# A47 North Tuddenham to Easton

**Scheme Number: TR010038**

## **Volume 9** **9.23 Applicant's Responses to Deadline 5** **Comments**

**9.23 APPLICANT'S RESPONSE TO DEADLINE 5 COMMENTS**

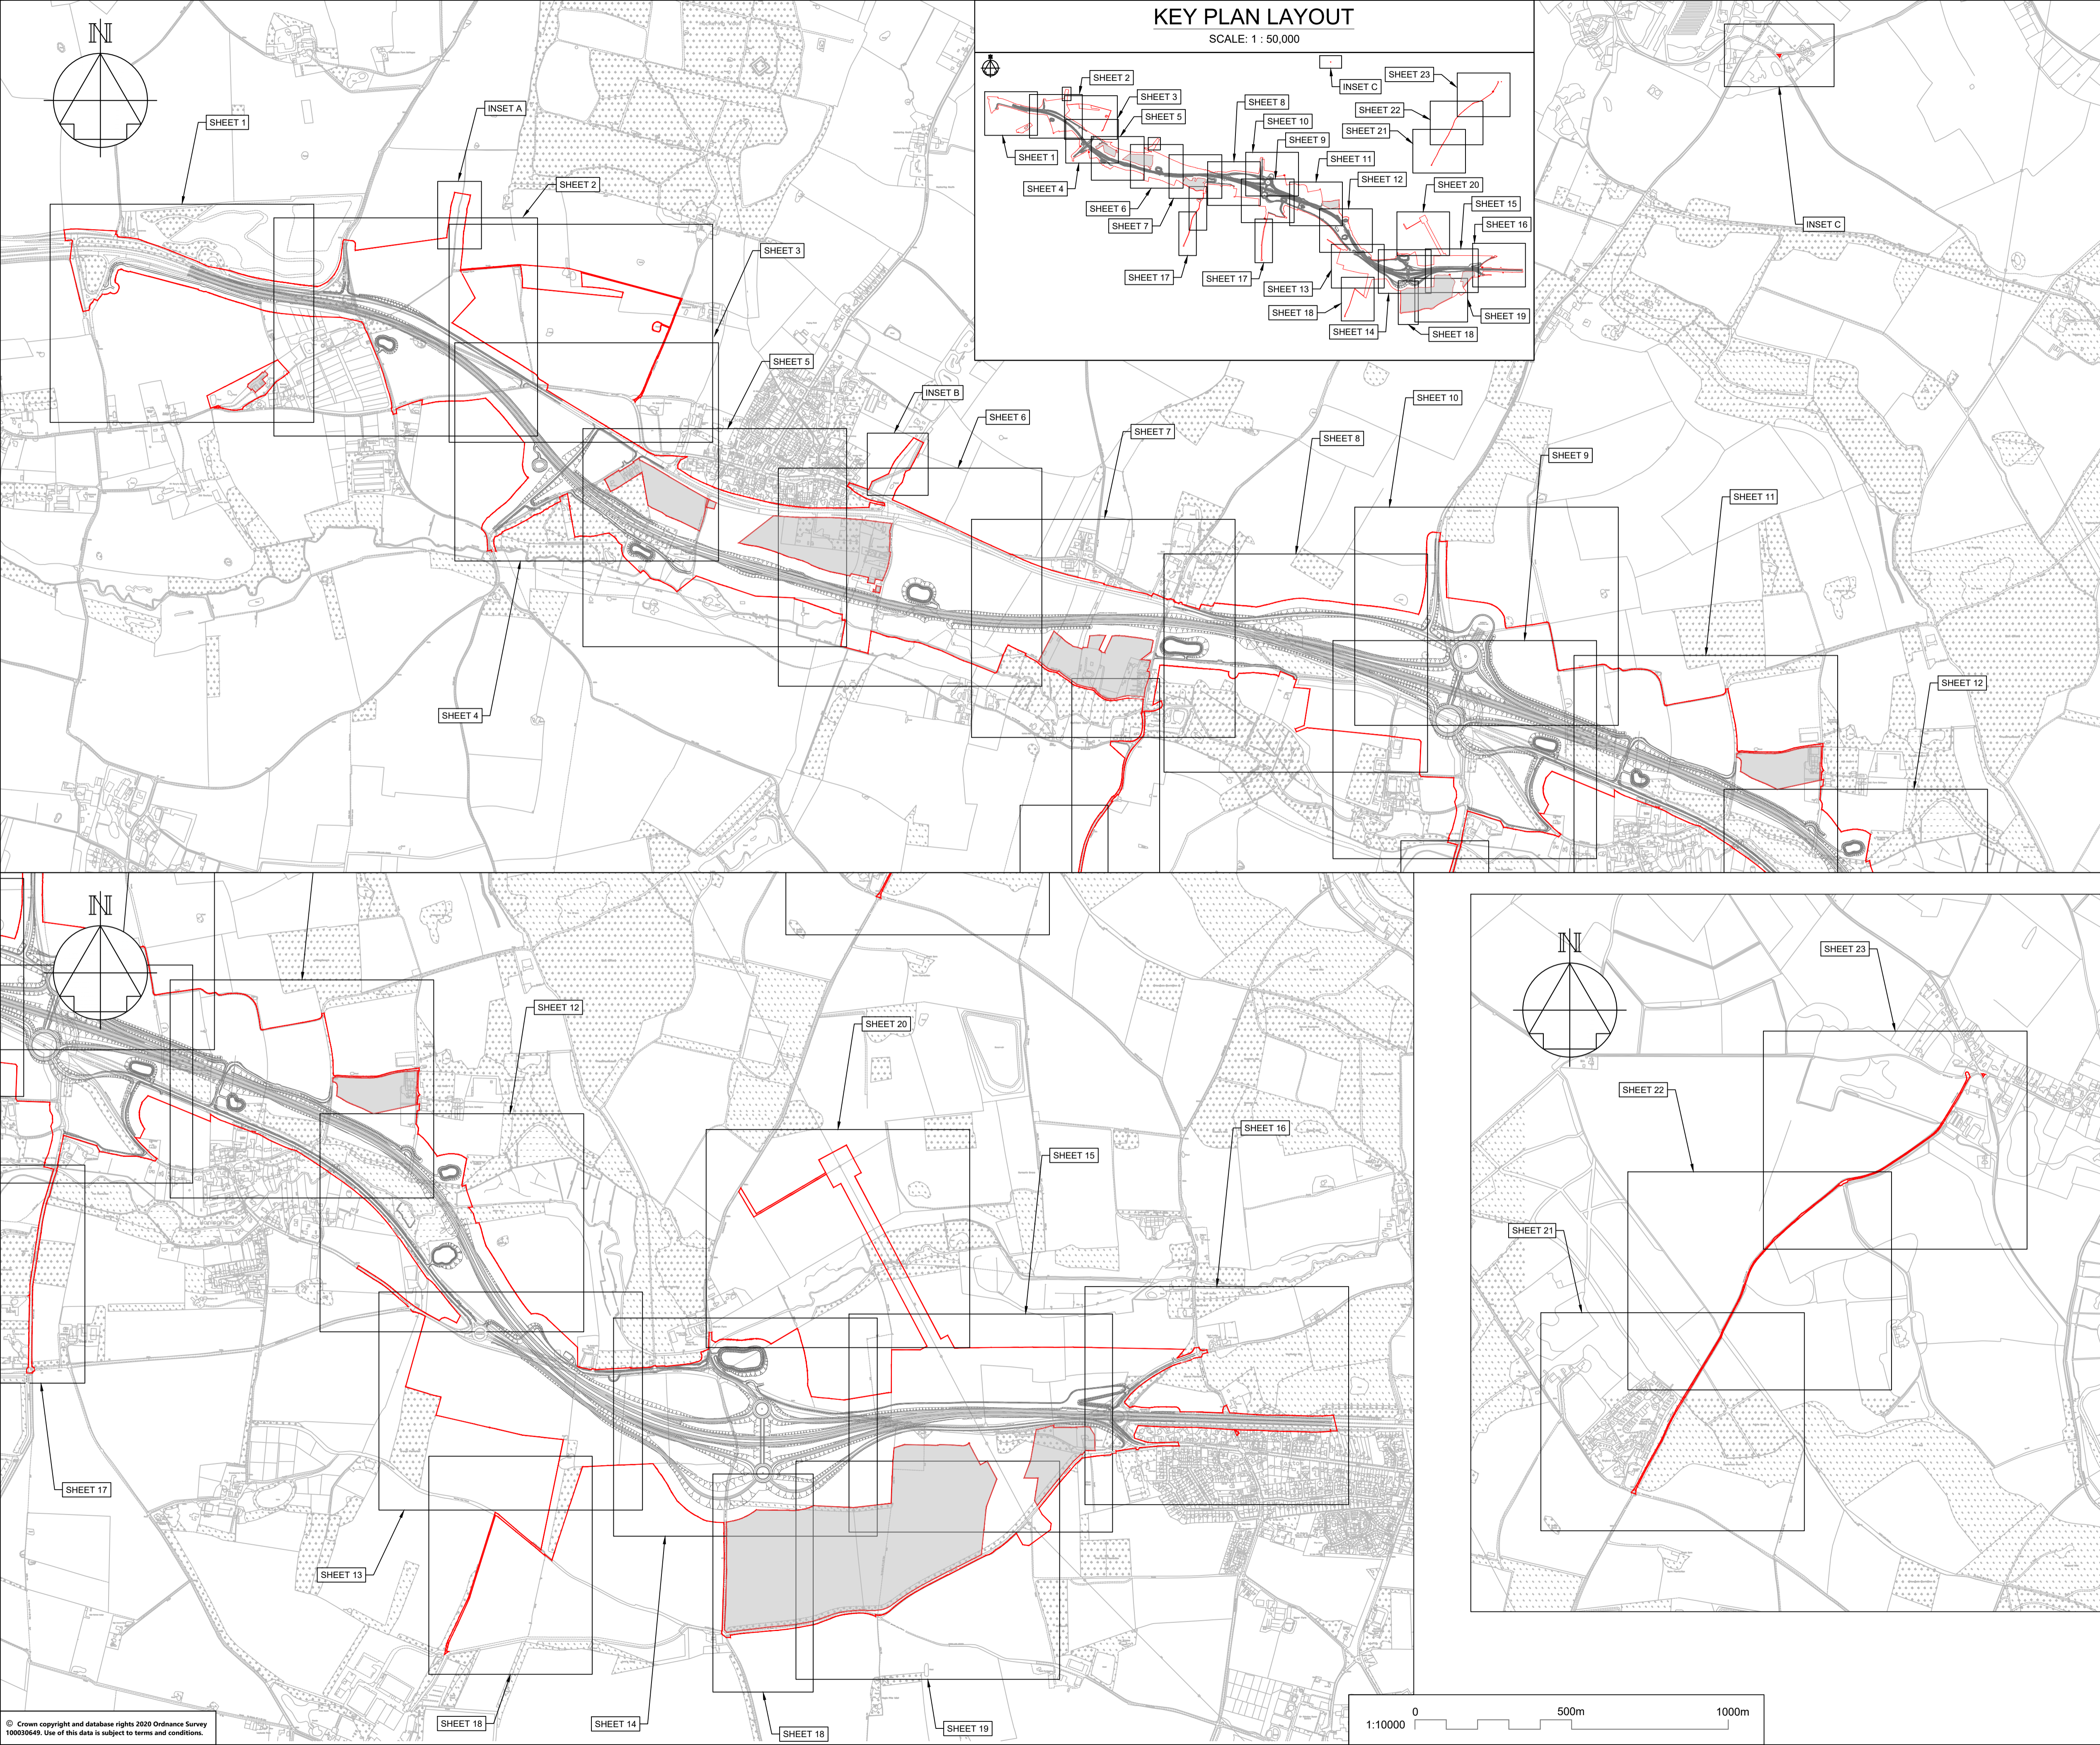
- **Anglian Water pipeline diversion** around the south side of the southern roundabout. The alternative design options avoid this, however the Applicant is currently exploring with Anglian Water the potential to retain or divert the existing pipeline in-situ under the southern roundabout in the Scheme design to avoid the need for a diversion south of the roundabout and associated impact on landtake. This opportunity is reflected in the utility diversion investigation area illustrated in the utilities

limit of deviation for diversion works shown as orange hatching on sheet 9 of the Works Plans (REP3-003). The ability to achieve this outcome will be confirmed at the detailed design stage in liaison with Anglian Water, who have indicated a willingness to explore this option but want to see the detailed design of the junction before agreeing to any such proposal.
